Our Ref: BE/107/18/PL
Your Ref:

Town & Country Planning Act 1990 (as amended)
Town and Country Planning (Development Management Procedure) (England) Order 2015
Application for Planning Permission

Development 1 No. attached dwelling.
Location 42 Westfield Bersted

PROPOSED ELEVATIONS

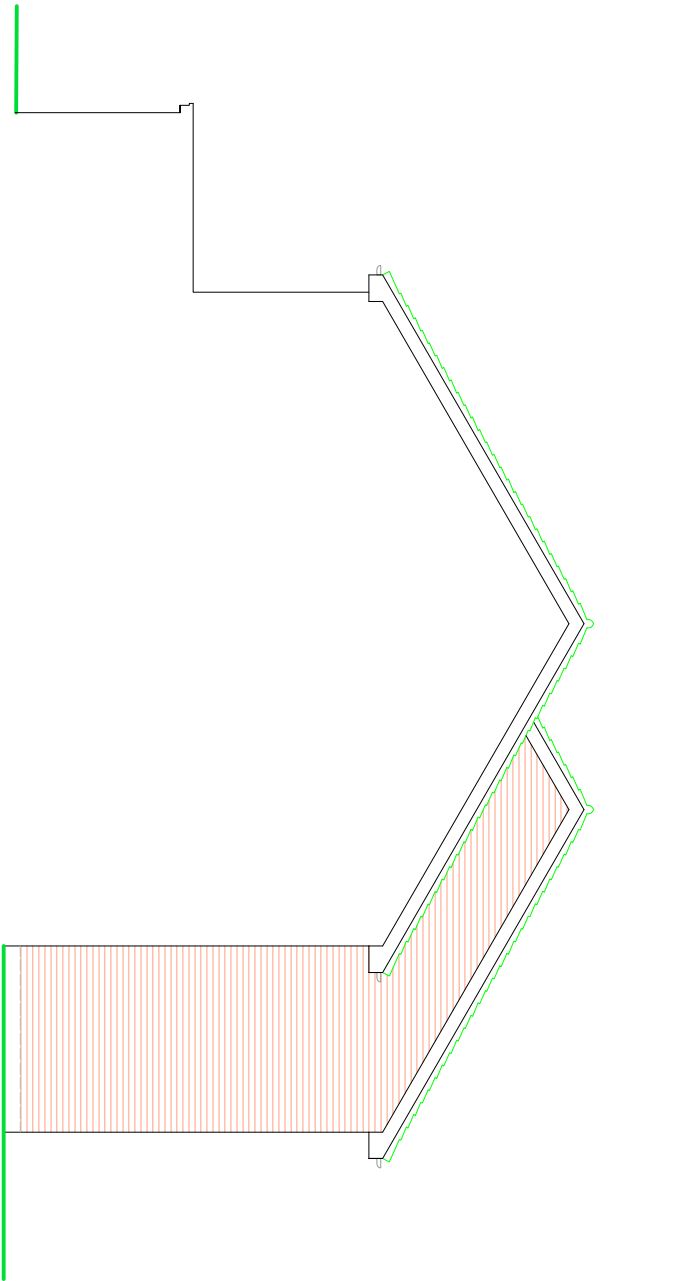
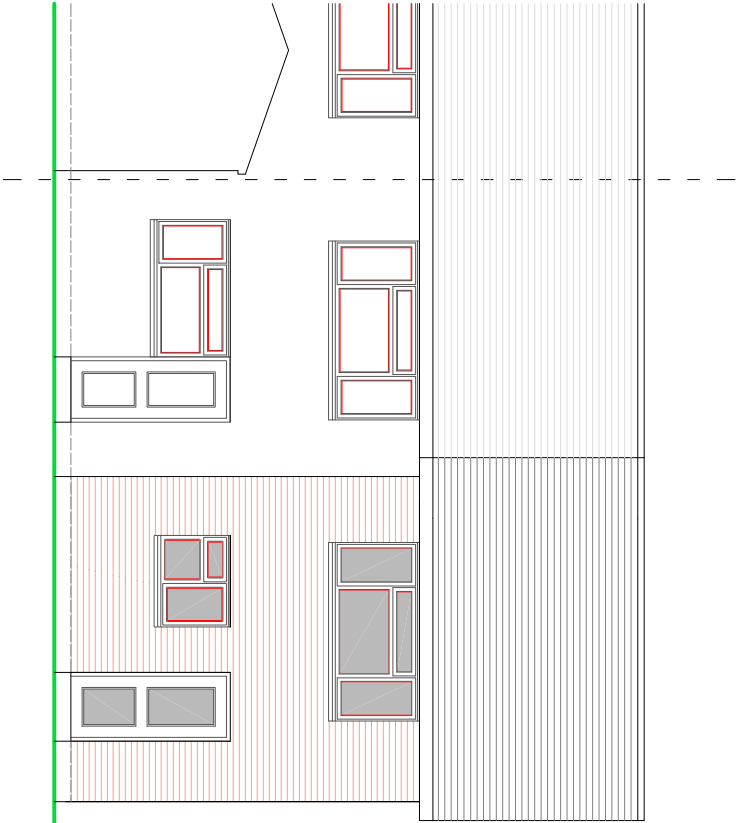
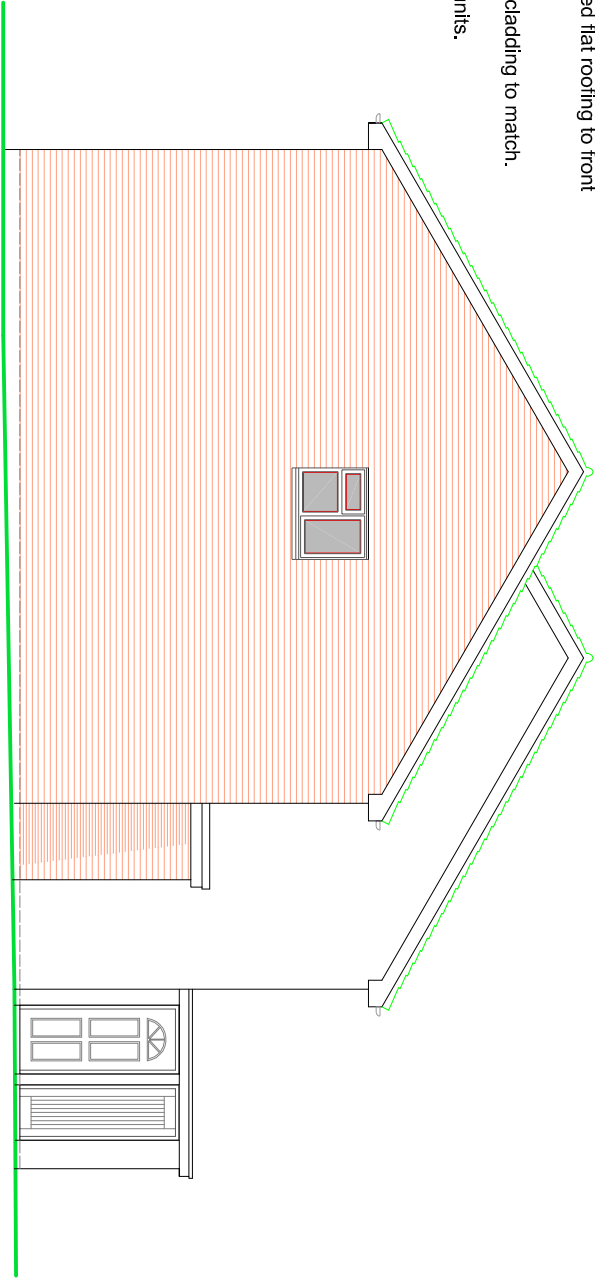
The proposed first floor plan and side elevation do not accord. Please amend accordingly.
Pagham Harbour Management Contribution Legal Agreement and Fee
